DECISION DELEGATED TO HEAD OF PLANNING

Application No: H13-0994-25 **Applicant:** D Brown (Building Contractors)

Proposal: Proposed change of use of existing agricultural land to builders yard

Location: Land West Of Browns Yard Seas End Road Moulton Seas End

PROJECT	Change of use Land North of Seas End Road Moulton Spalding
DATE	September 2025
TITLE	Existing and Proposed Site Plan
SCALE	1:500
ORIGINAL SIZE	A1
DRG STATUS	PLANNING
DRAWING NUMBER	LDC4786-01A

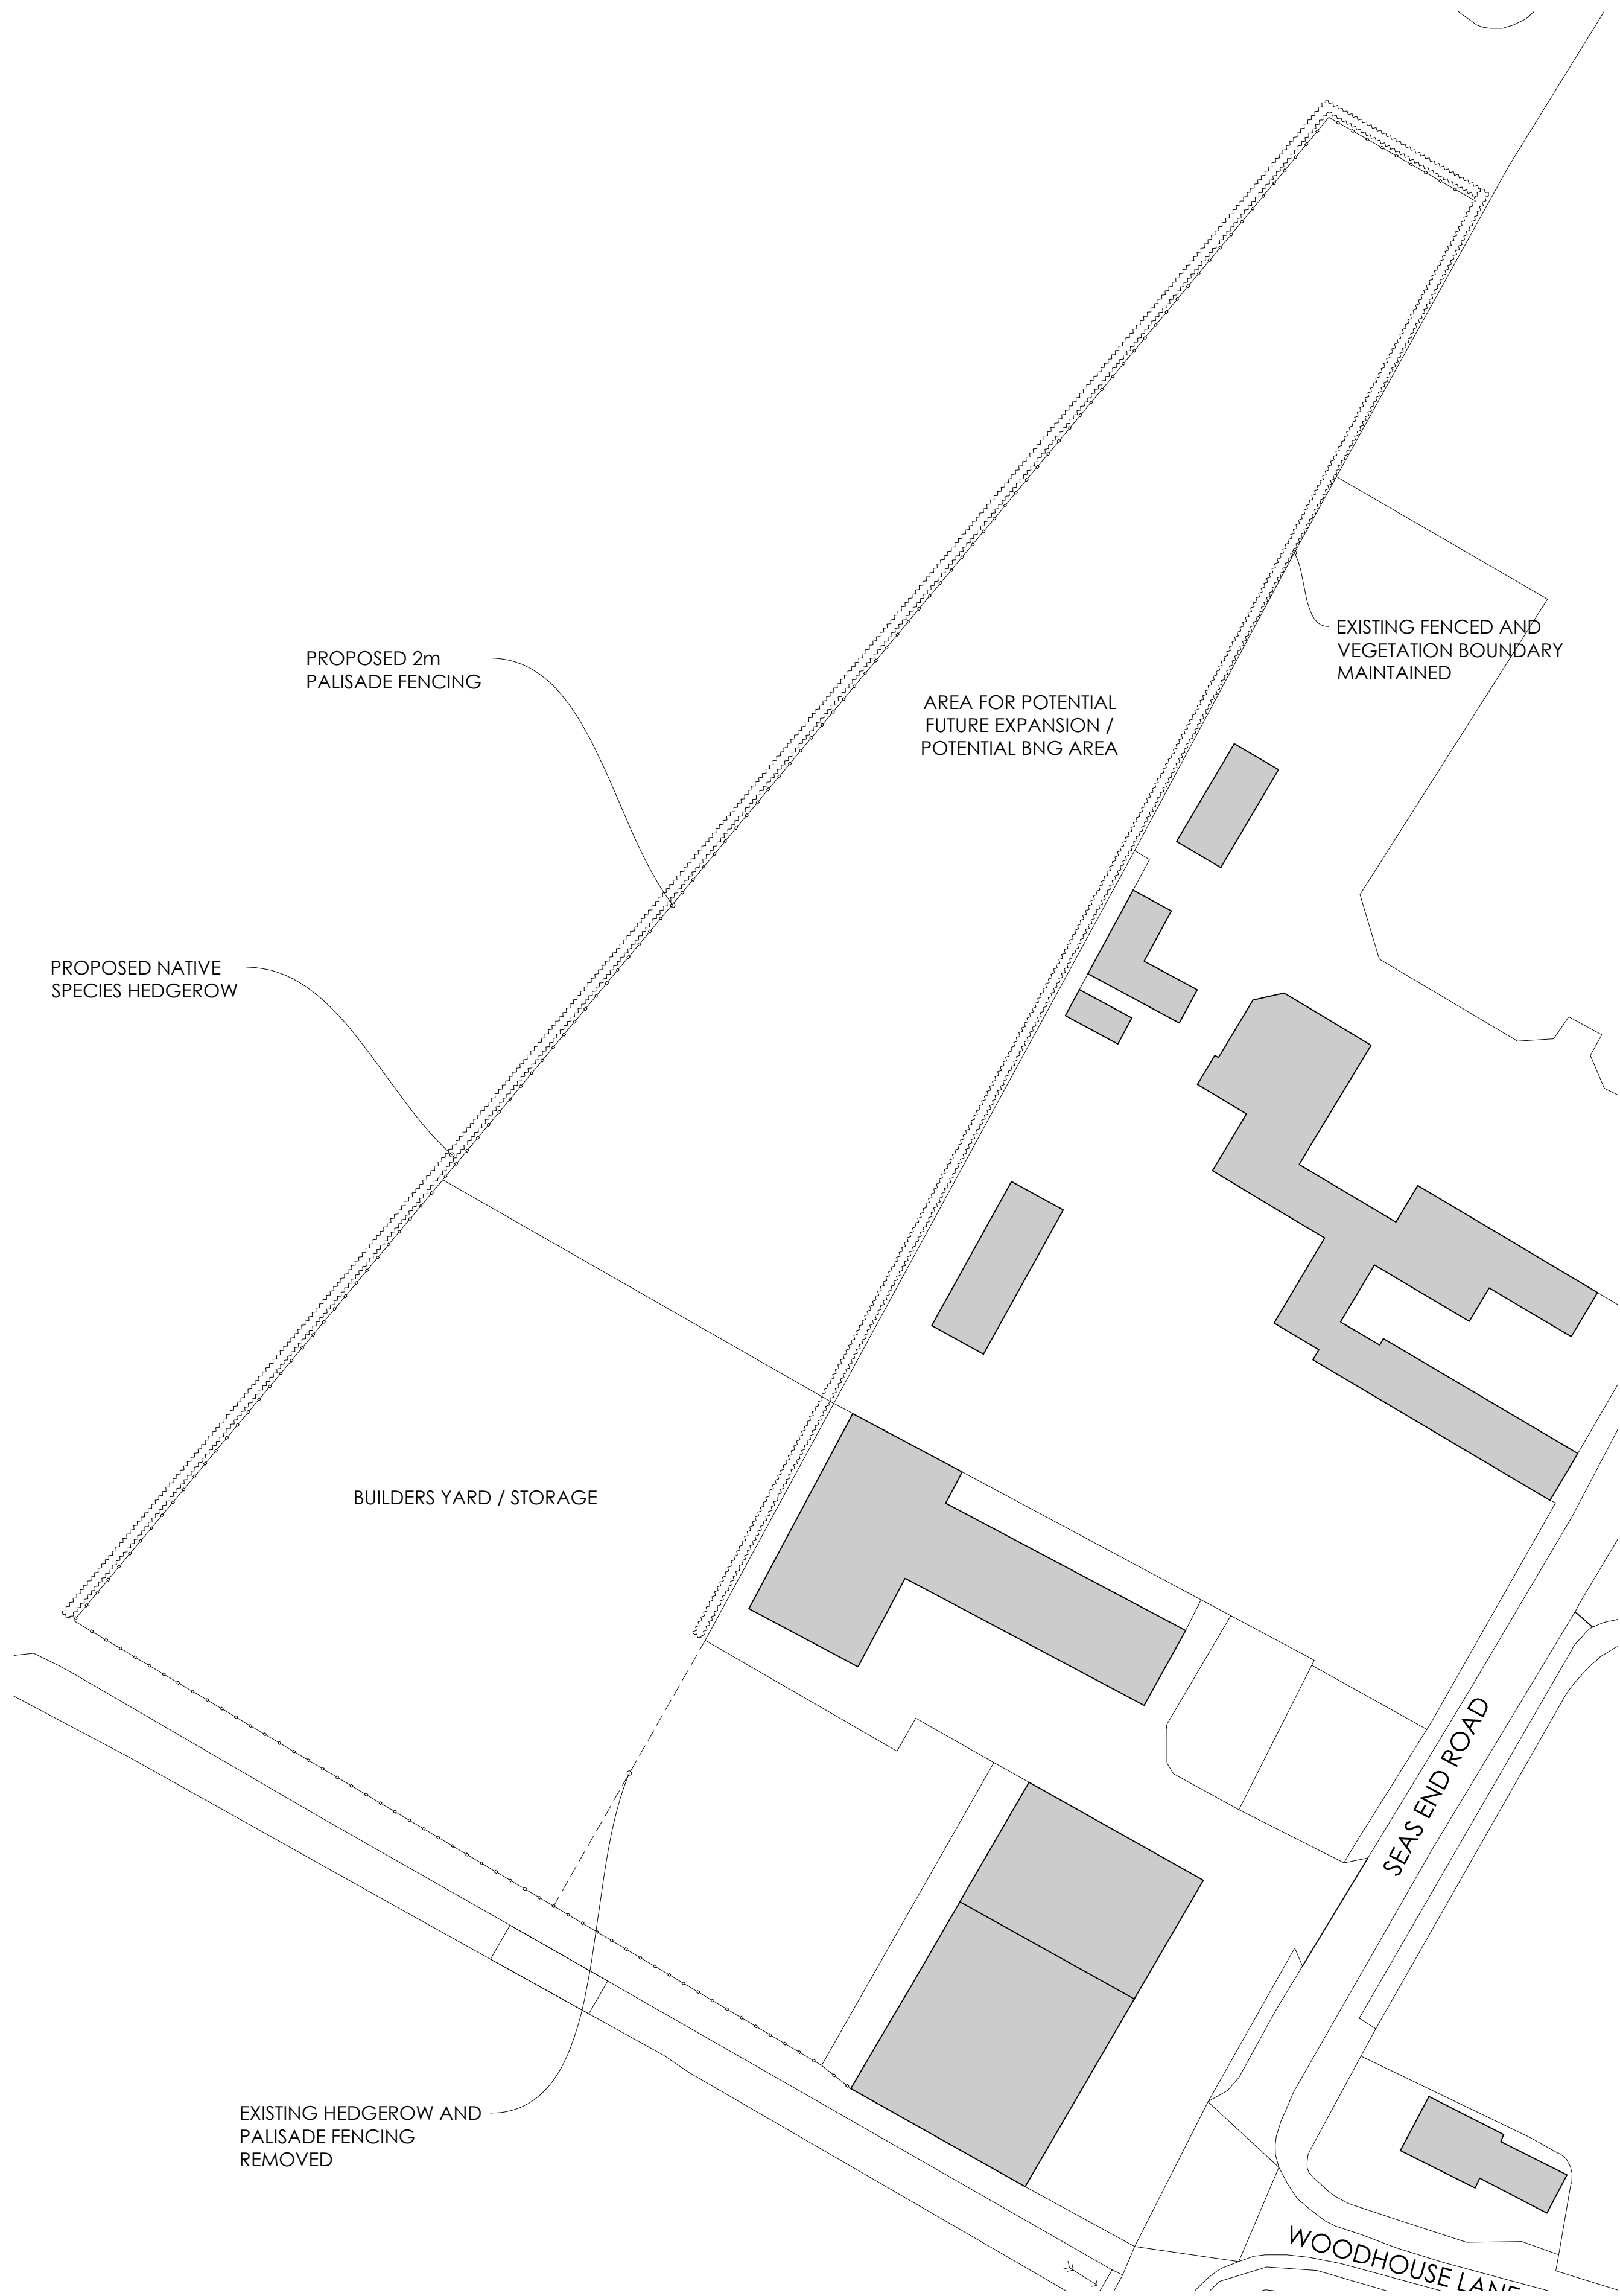
The application site is shown to be enclosed by a 2m high palisade fence and native species hedgerow.

Object. The new fence and hedgerow will impact the ability of the Board to access the watercourse to carry out future operations and will also likely increase the liabilities of the Board.

The development would represent open storage in the countryside, with an industrial fence and is therefore not responsive to the local context. Whilst it is noted that the adjoining site, that of the existing business would be present, this would not in itself justify further expansion or sprawl into the countryside or rural setting.

The applicants have indicated that they would be happy to amend the current plans so that the fence in question is moved inwards within our boundary to keep the clear 9m easement along the new length. Thus removing any requirement for consent or objection. These plans have not been submitted on the basis of likely refusal of the application on principle.
